CASTLE GROUP

SSD-9472 Sikh Grammar School
Lots 42 & 43 DP30186 151-161 Tallawong Road Rouse Hill

The following forms our submission regarding the above Development Application for a proposed school. We are making a submission on behalf of 114 Tallawong Road Rouse Hill (KMA Developments No 6 Pty Ltd ATF KMA Developments No 6 Unit Trust).

8 Southern Perspective
Scale: 1:100

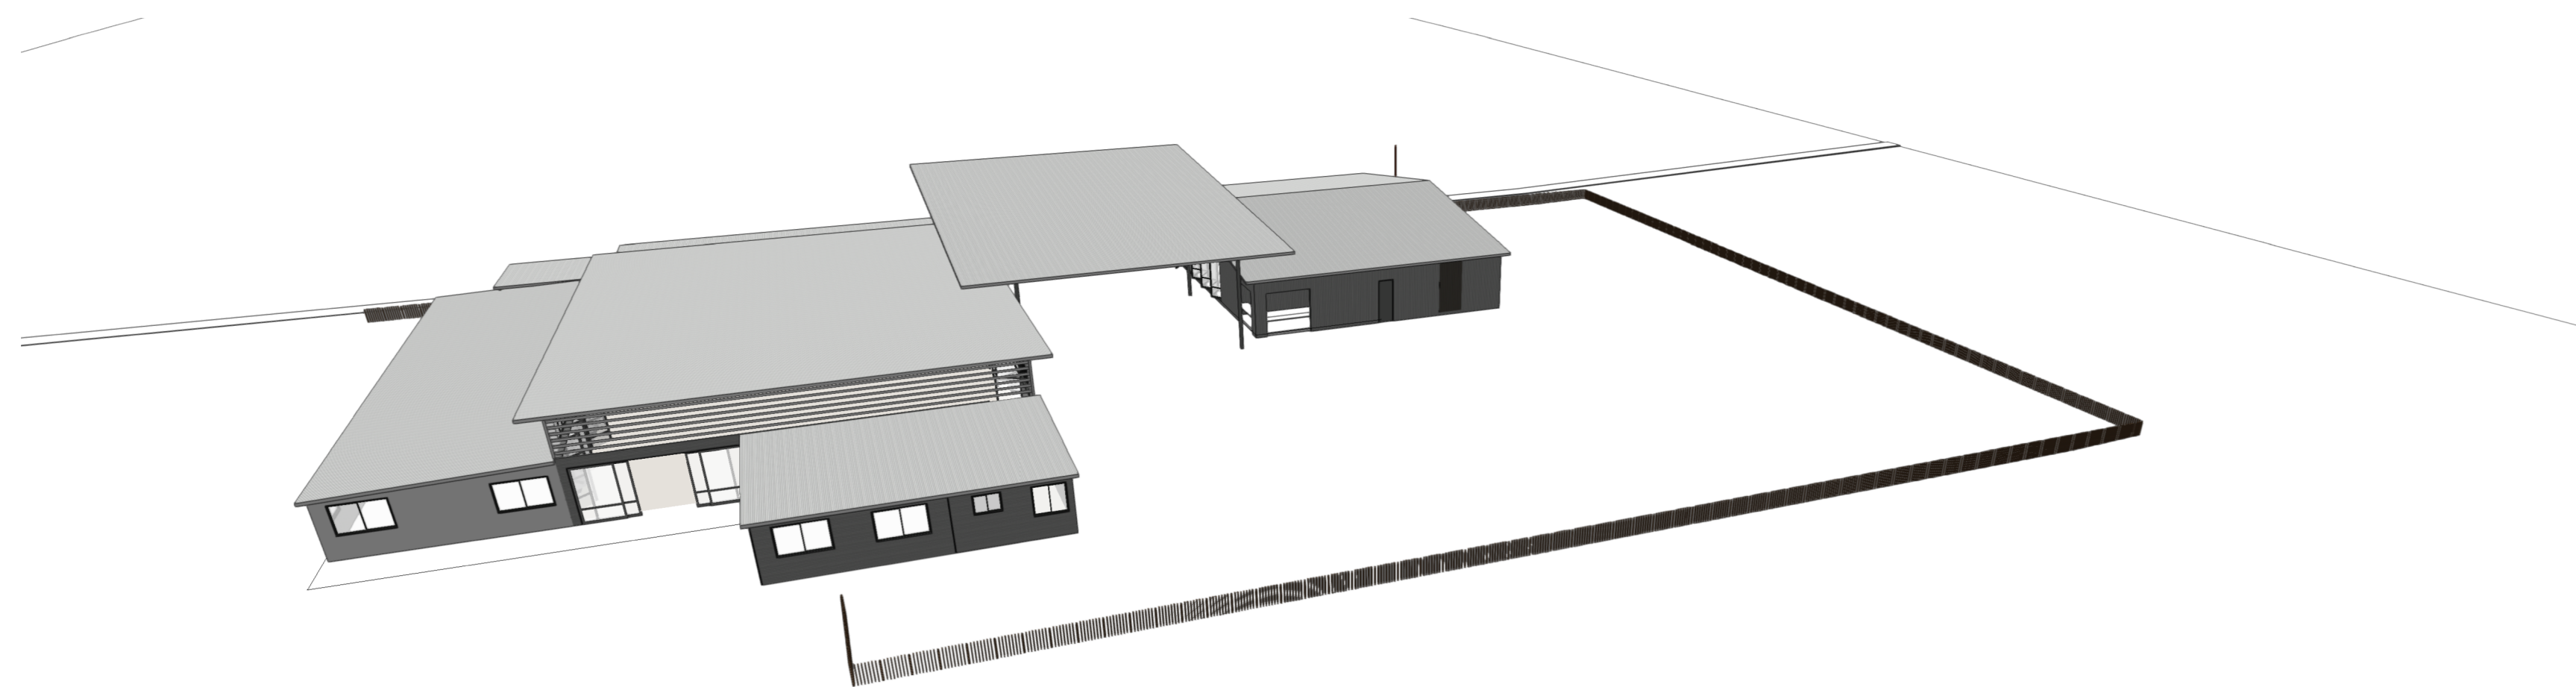
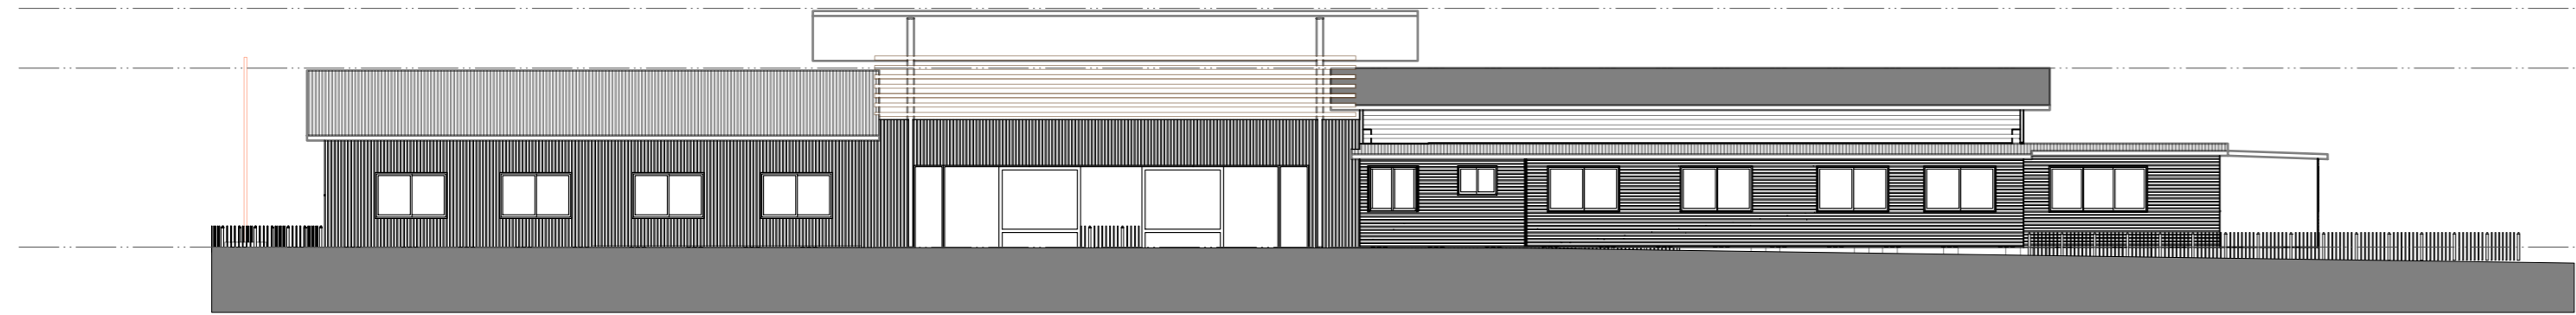
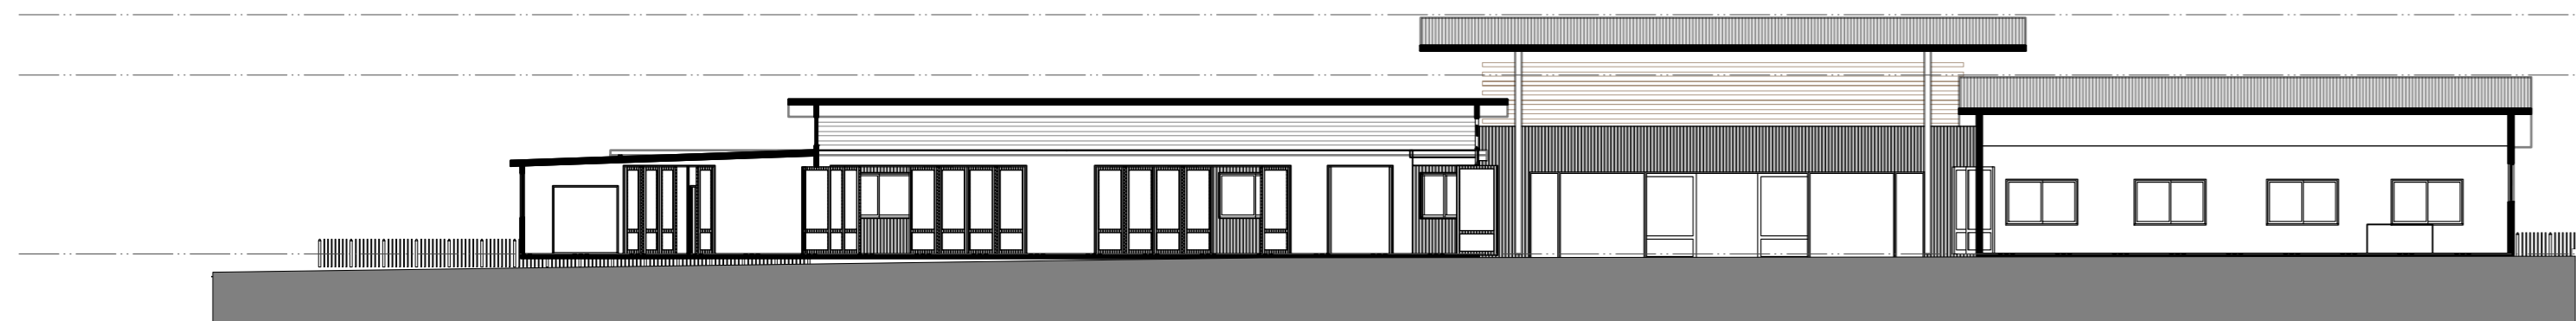
The proposal seeks a maximum building height of more than double the existing height limit at 18.19m. The justification for this significant breach relies on the commercial viability, operational requirements of the school and demand for infrastructure.

The application fails to provide adequate justification as to why the departure from the development standard is unreasonable or unnecessary or that the development presents a better outcome for the site as a result of the non-compliance. The commercial viability of a project is not a valid planning consideration and the operational requirements of the school can be equally served by a development of lesser scale that occupies a greater land area.

- The survey plan is illegible as only Sheet 1 has been included whereas Sheets 2-7 which have not been included presumably provide a greater scale and legible text.
- The architectural plans do not provide any measurements from natural ground level making precise measurement of the building height and impact on the adjoining properties difficult.
- There are significant inconsistencies between the masterplan and the architectural plans. Building locations are substantially changed, land uses have been relocated and parking areas, bus layby and access arrangements are different.

01 PLAN
Site- Overall
Scale 1:250

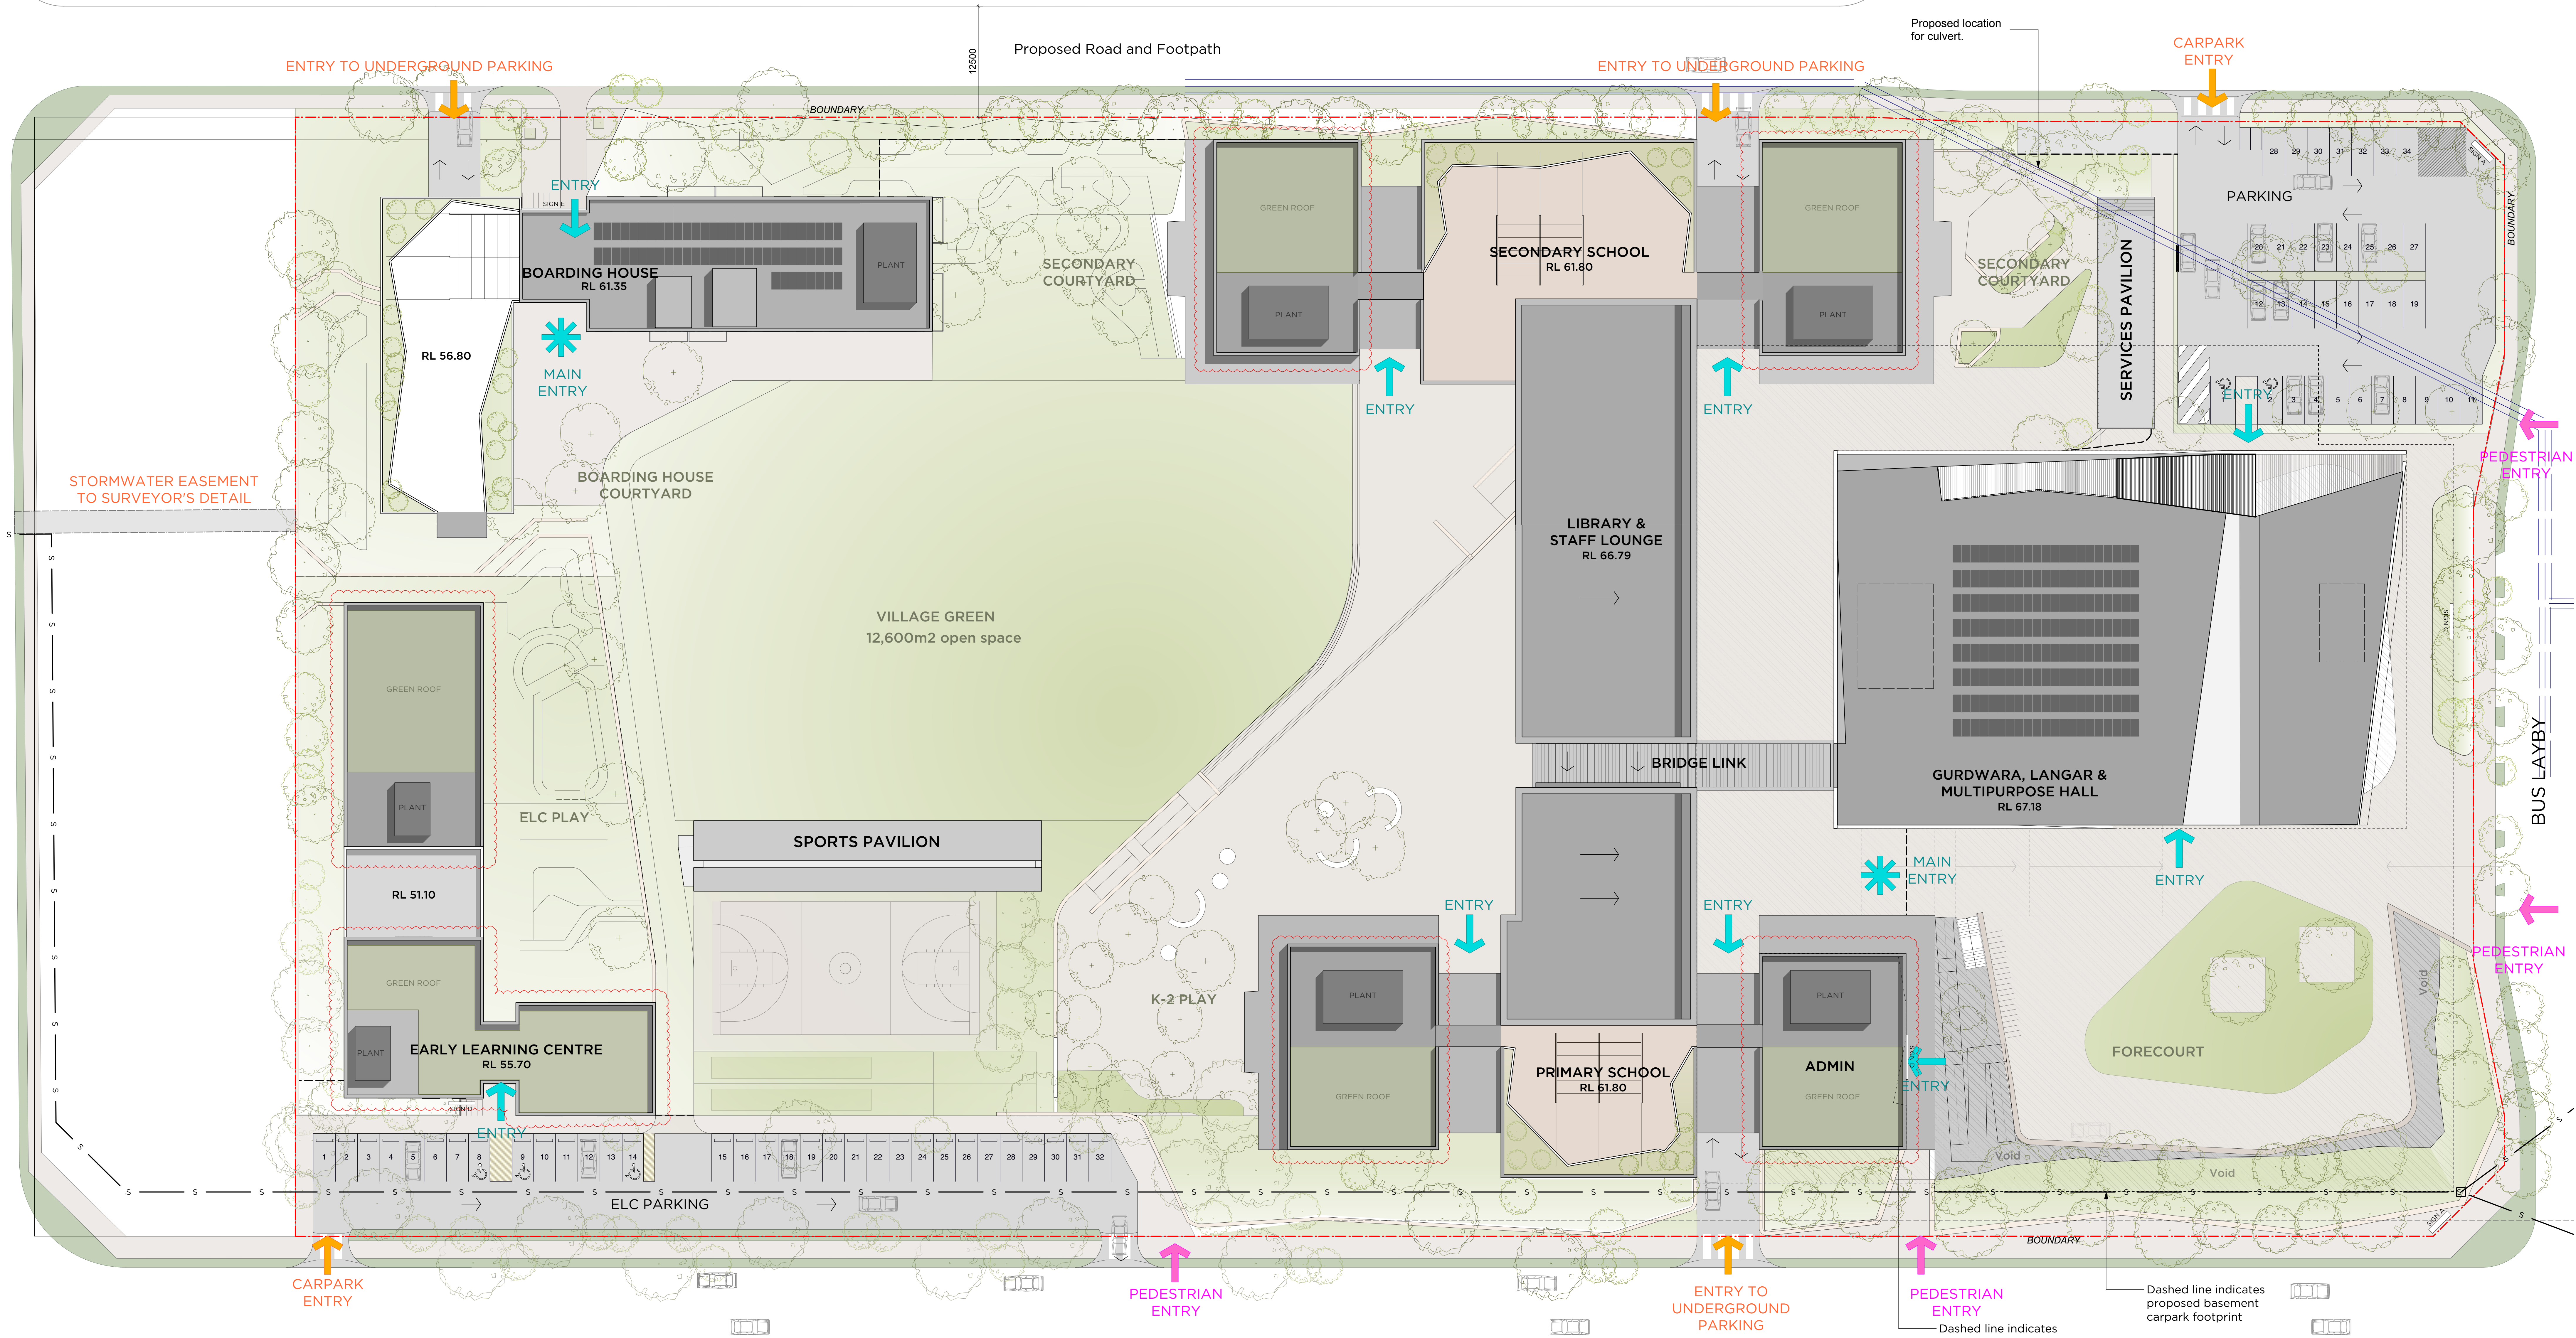
Vehicle access to the proposed basement is proposed to be via the new northern and southern roads. Further, access to the above ground parking is proposed to be provided via the northern half road.

In the interim and until such time as the neighbouring sites have been developed this access arrangement is problematic as these half roads are unlikely to be able to safely accommodate the vehicles movements expected to service the development during peak times.

Additionally, the turning manoeuvres indicated on the architectural plans cannot be accommodated without driving into our property, and no consent has been given to temporary or permanent works within our site.
